Re: OTT-00250806-A-C

Review of Grading Plan
Proposed Residential Development. Hazeldean Crossing
5924 and 5938 Hazeldean Road, City of Ottawa, ON

We have reviewed the grading plans prepared by EXP for this project and specifically Drawing C200-Rev 3, dated November 5, 2019 under Project OTT-00250806-B0.

PROJECT  
HAZELDEAN CROSSING TOWNS  
5924 HAZELDEAN ROAD  
OTTAWA, ONTARIO.  
TITLE  
SITE GRADING PLAN

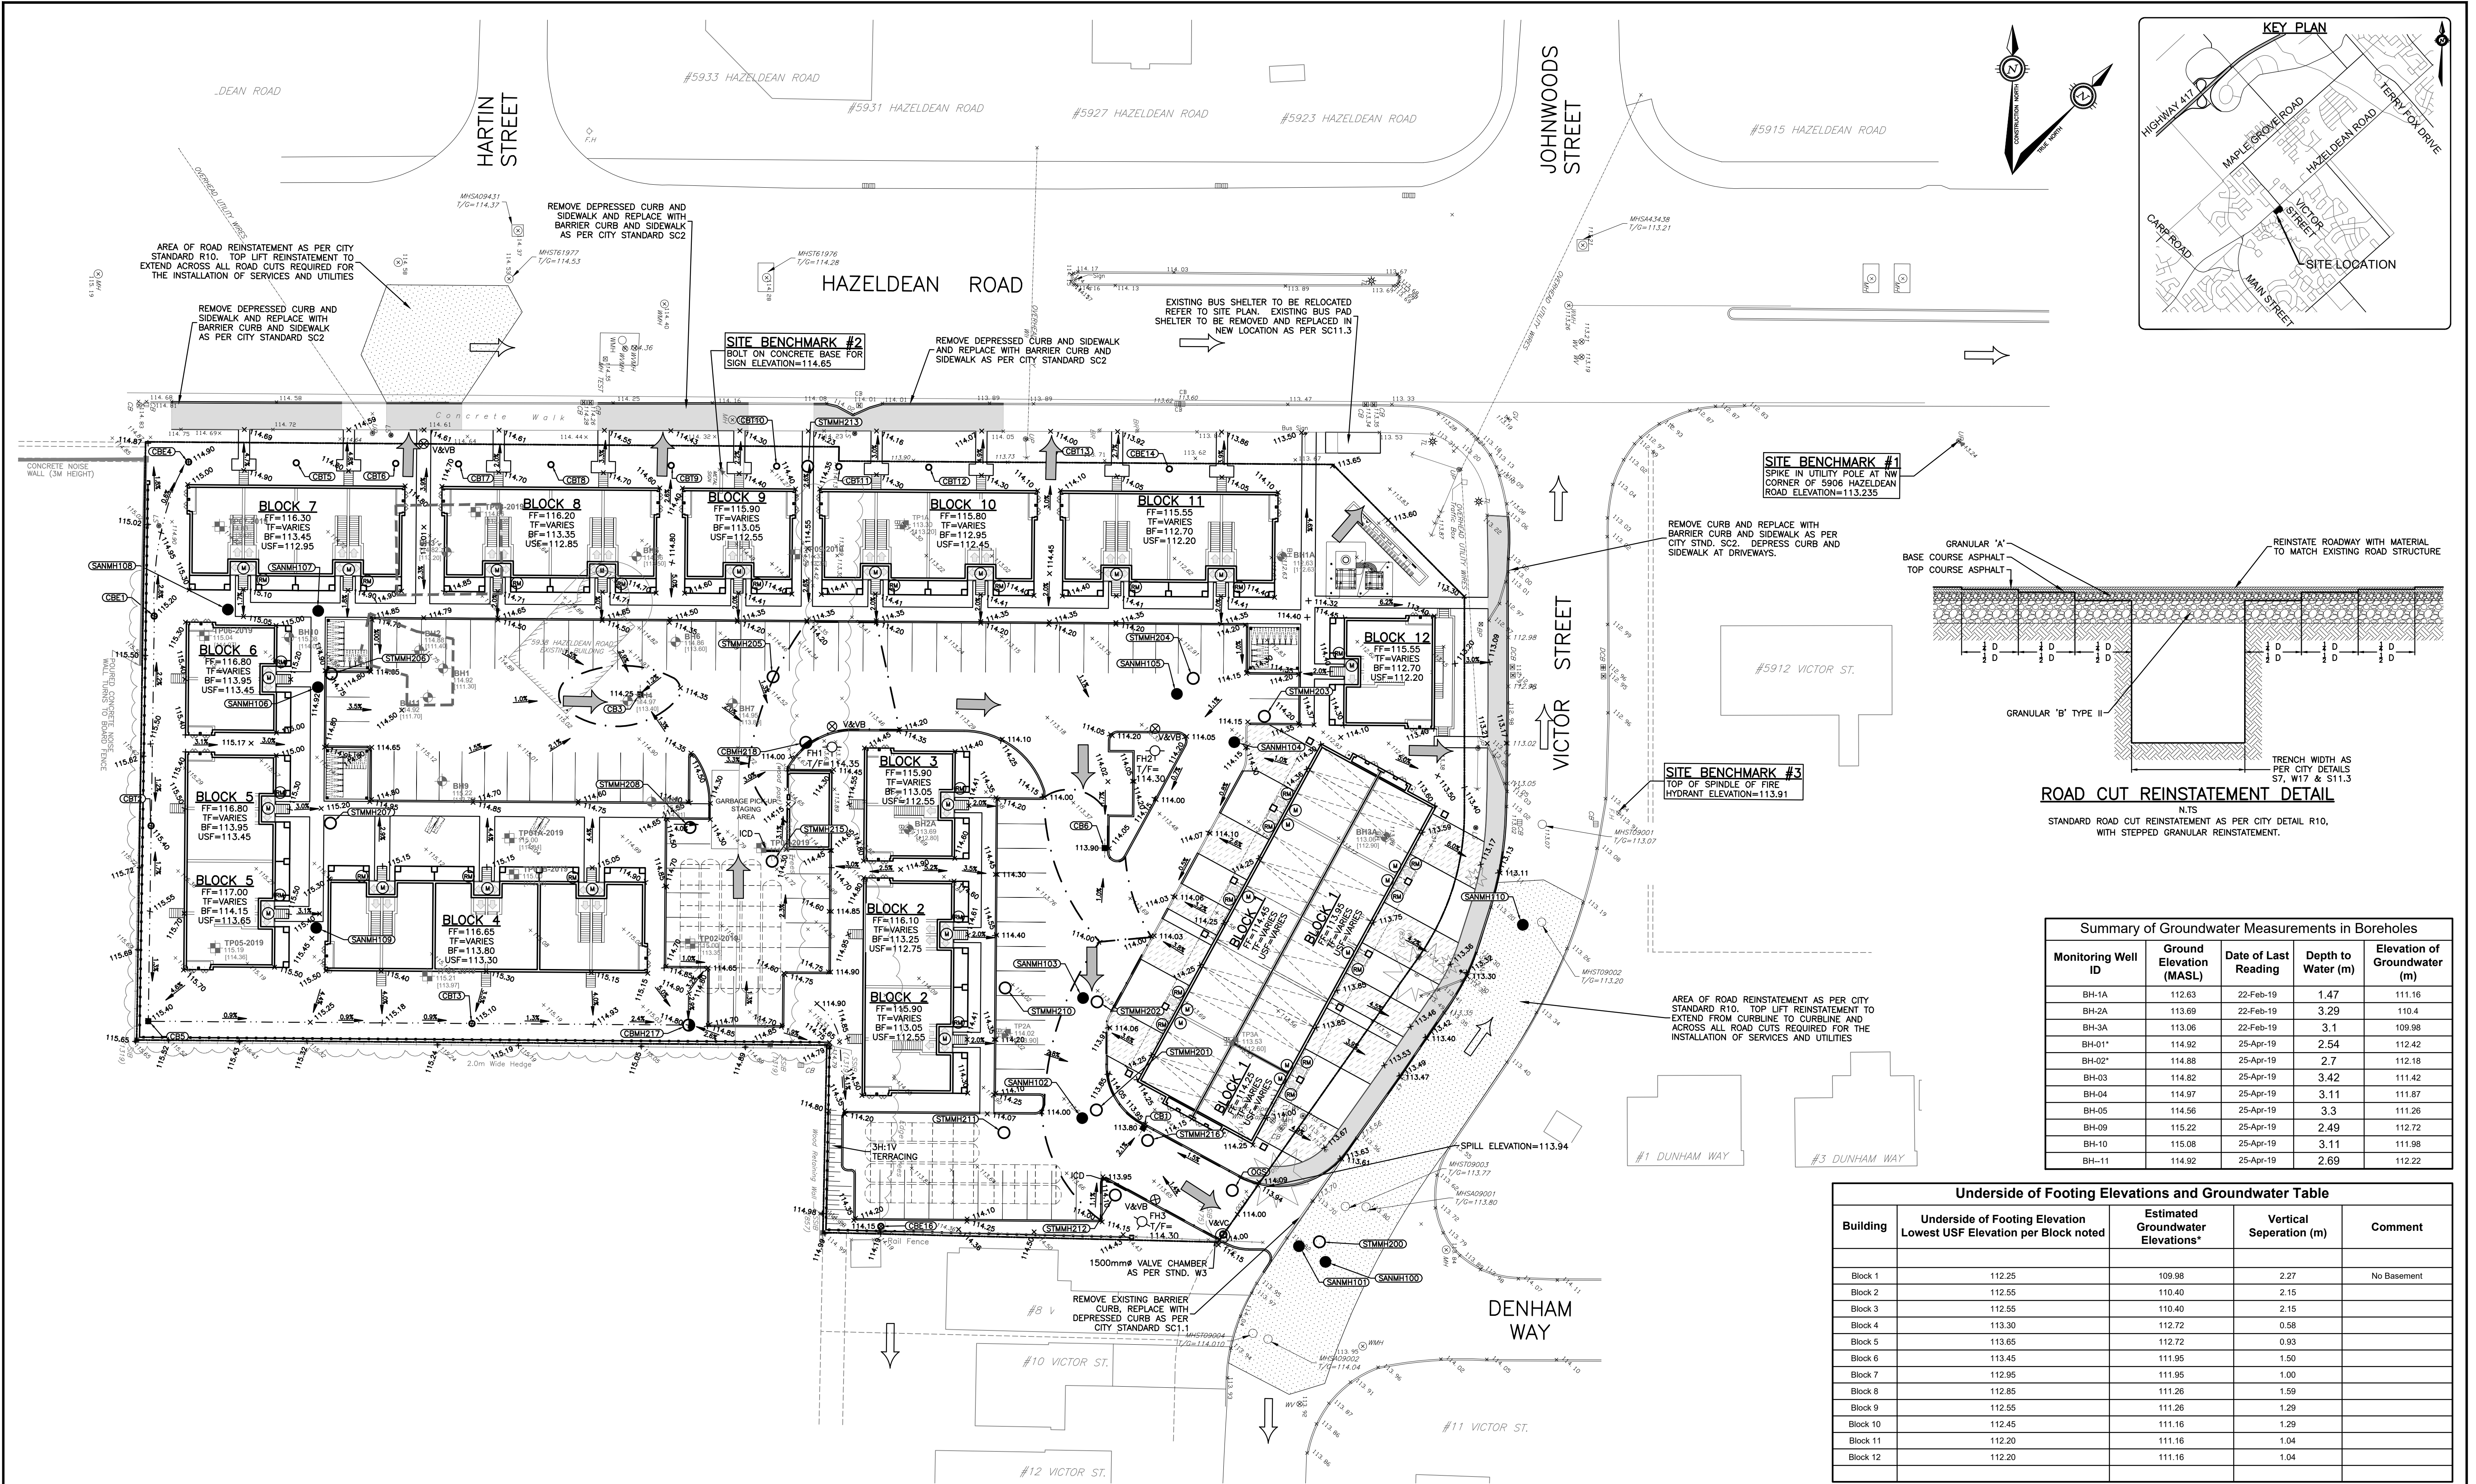
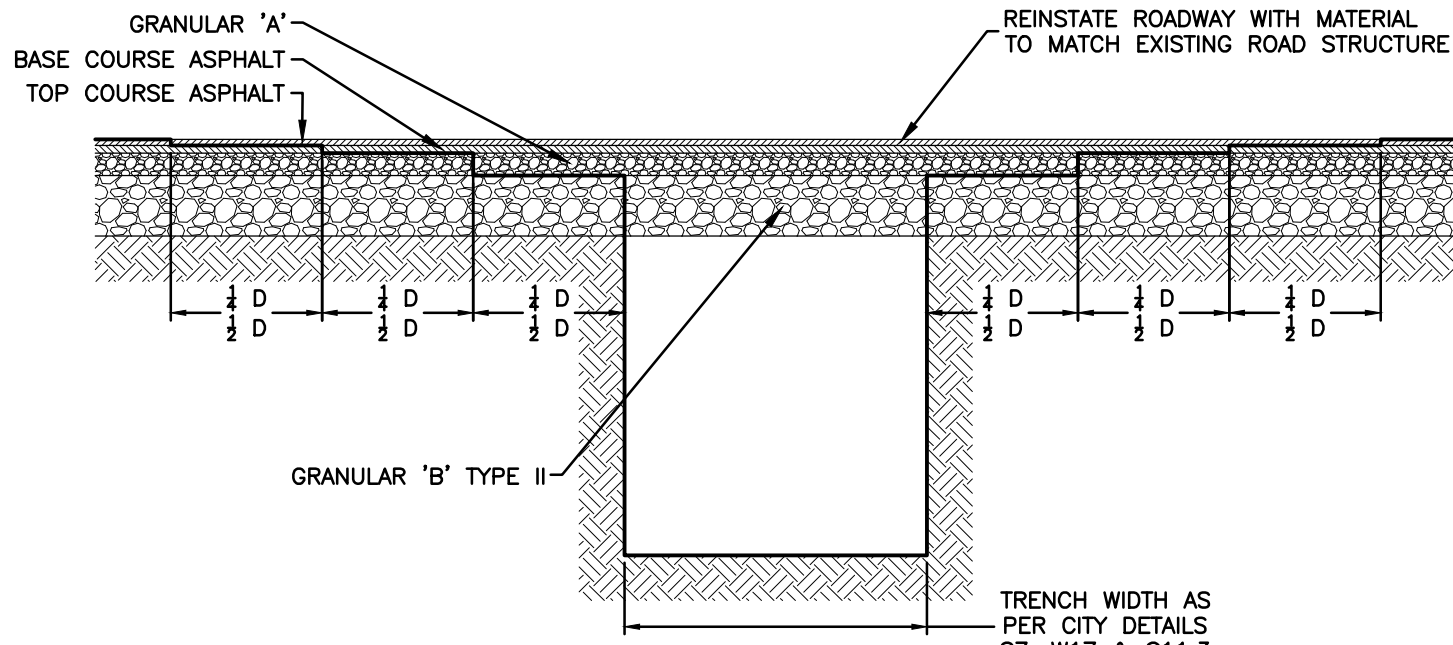
The review indicates a proposed grade raise of up to 3 m which is considered acceptable from a geotechnical point of view as the site is underlain by shallow bedrock.
